Application for Planning Permission for Works or Extension to a Dwelling

Development: Retrospective application for the erection of a 1.8m boundary fence adjacent to the public highway.
Location: 97 Arundel Road Littlehampton BN17 7DT

AR-208-04

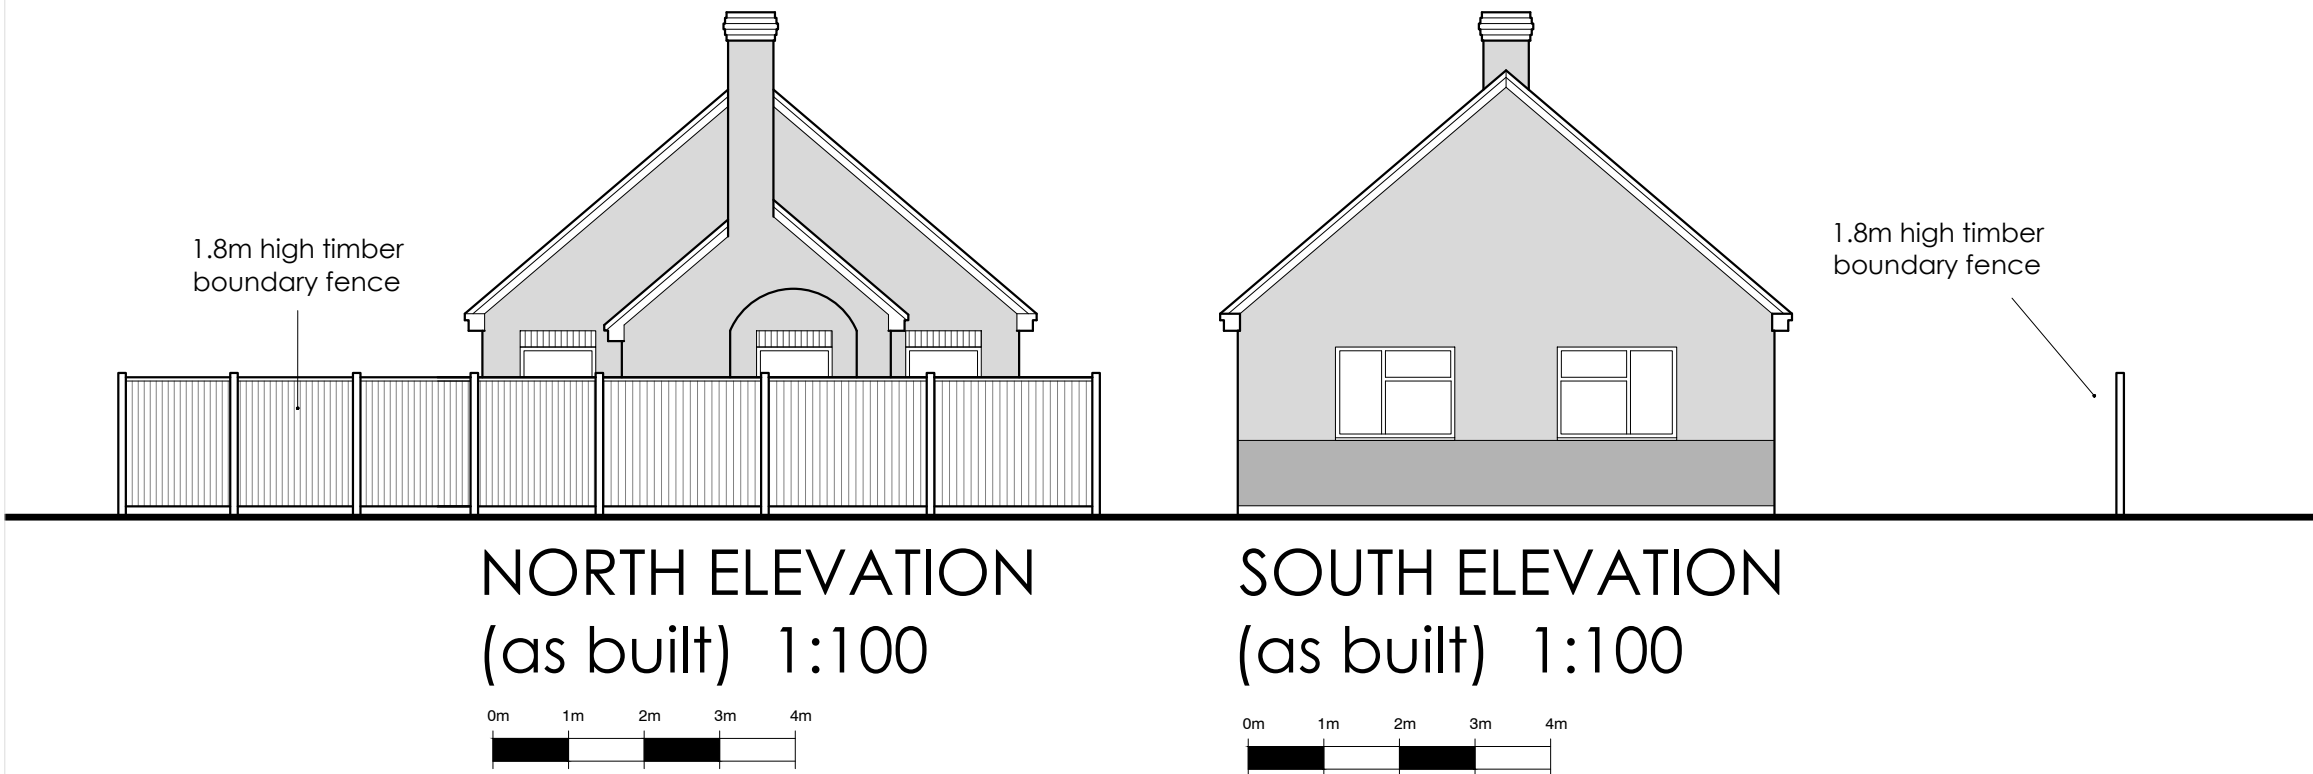
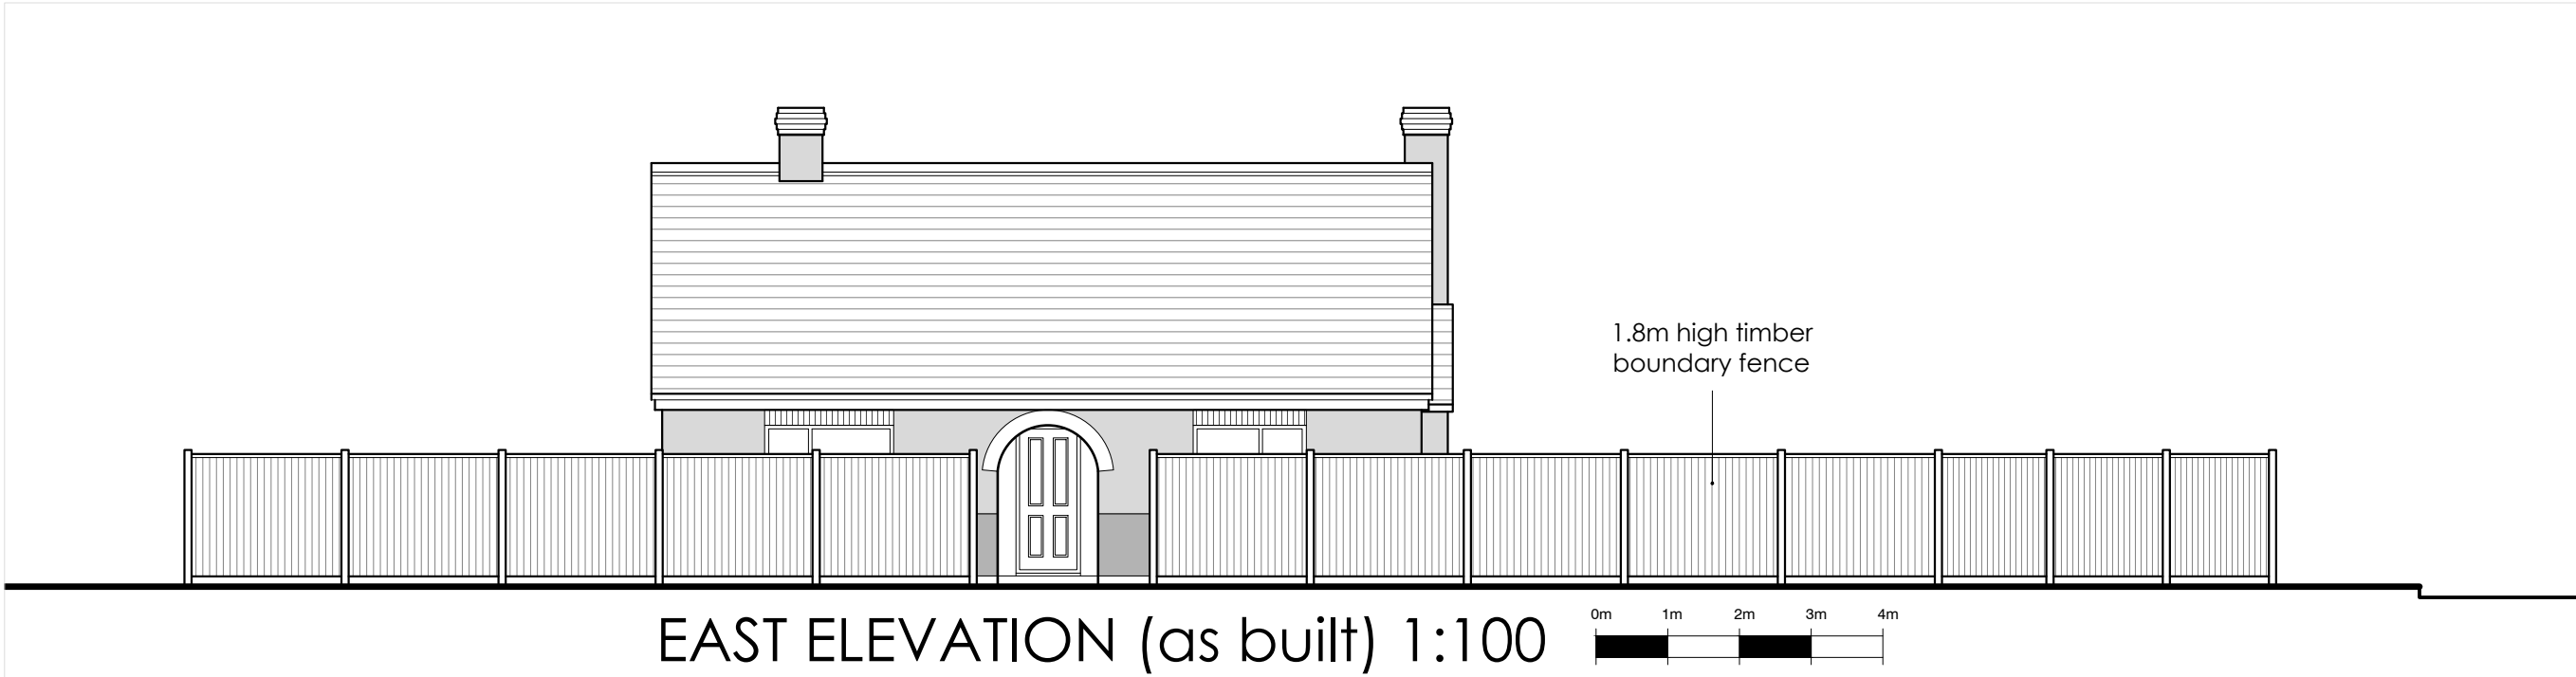
The proposed east elevation plan fence has a gap for access to the front door, this is not visible on the proposed site plan fencing and is therefore inconsistent, please amend.

The proposed south elevation plan fence is not consistent with the proposed site plan.

EXISTING EAST
ELEVATION 1:100

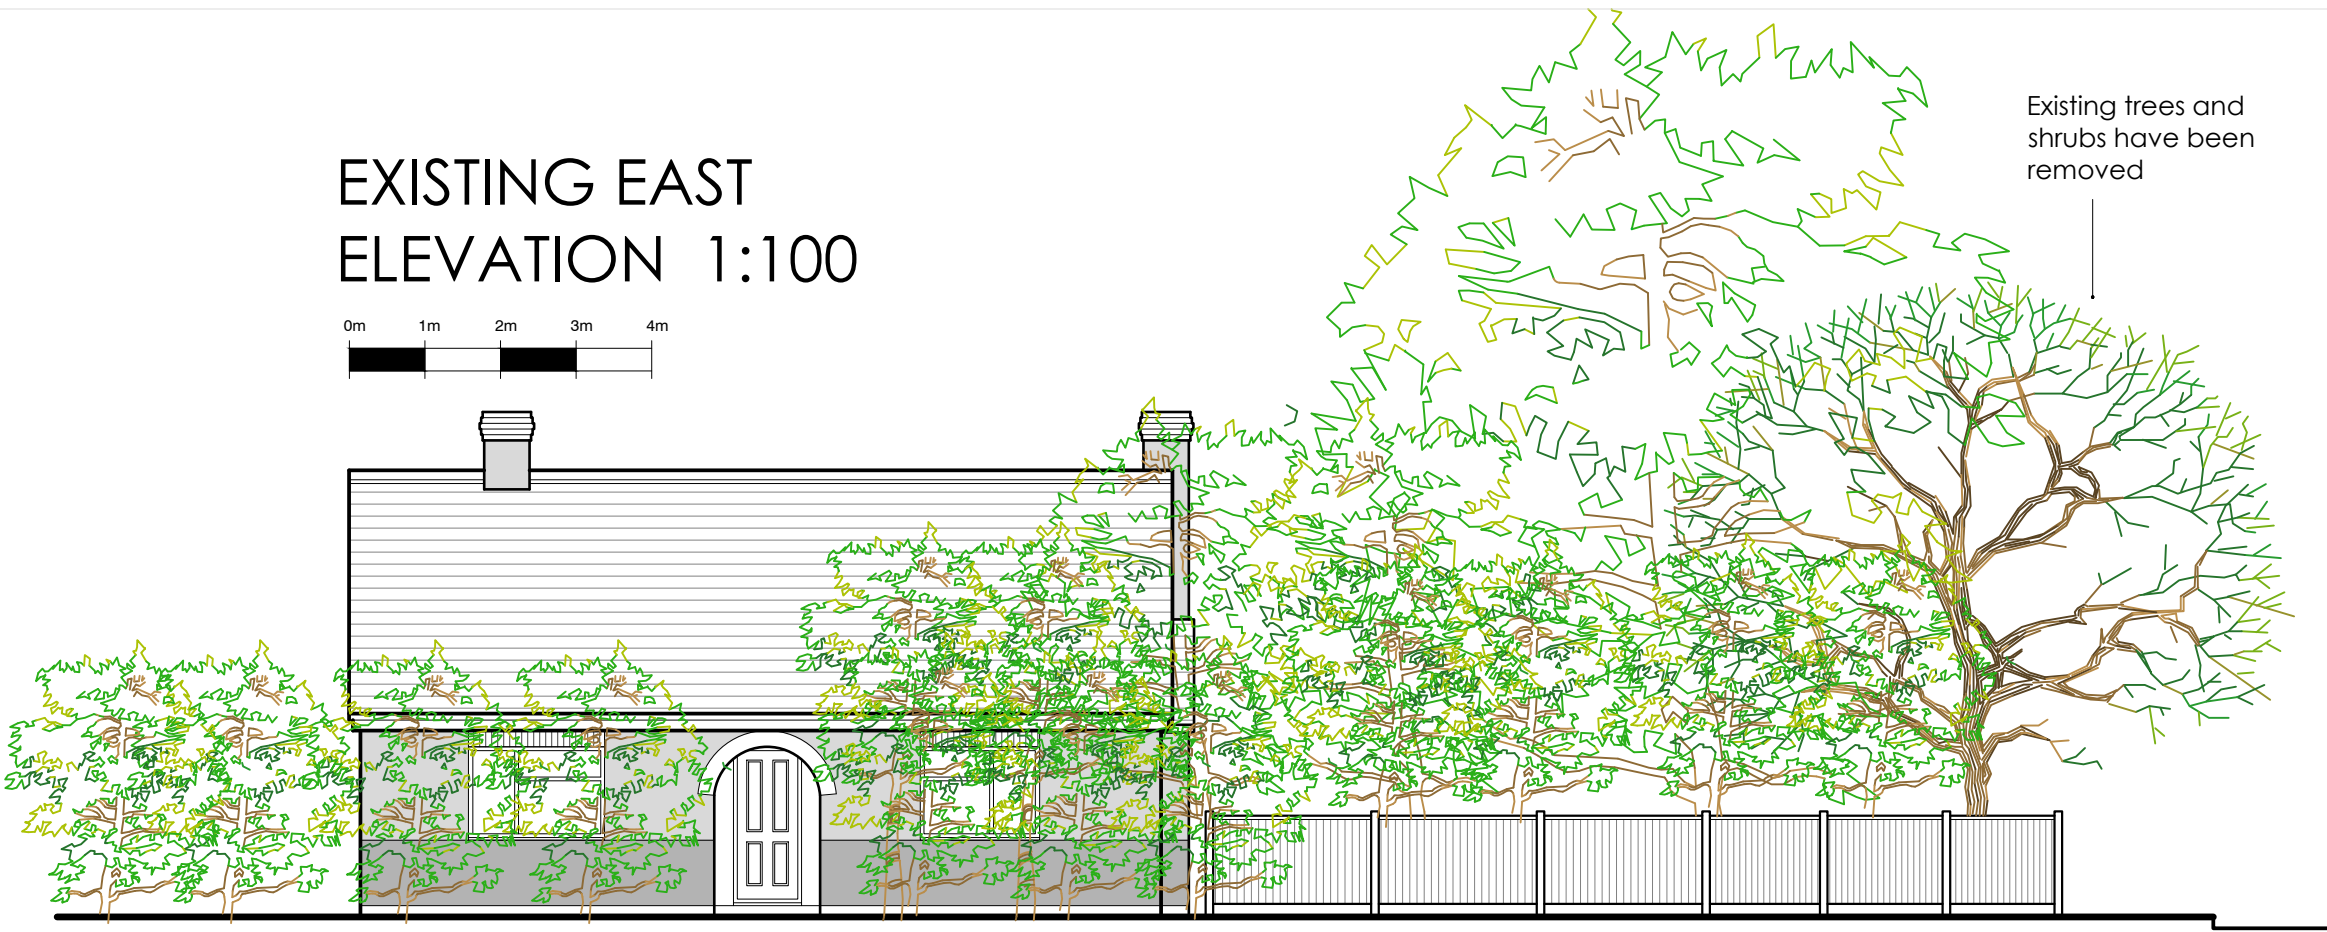
The existing site/block plan will need to show the previous fencing, this will have to be consistent with the existing elevation plans.
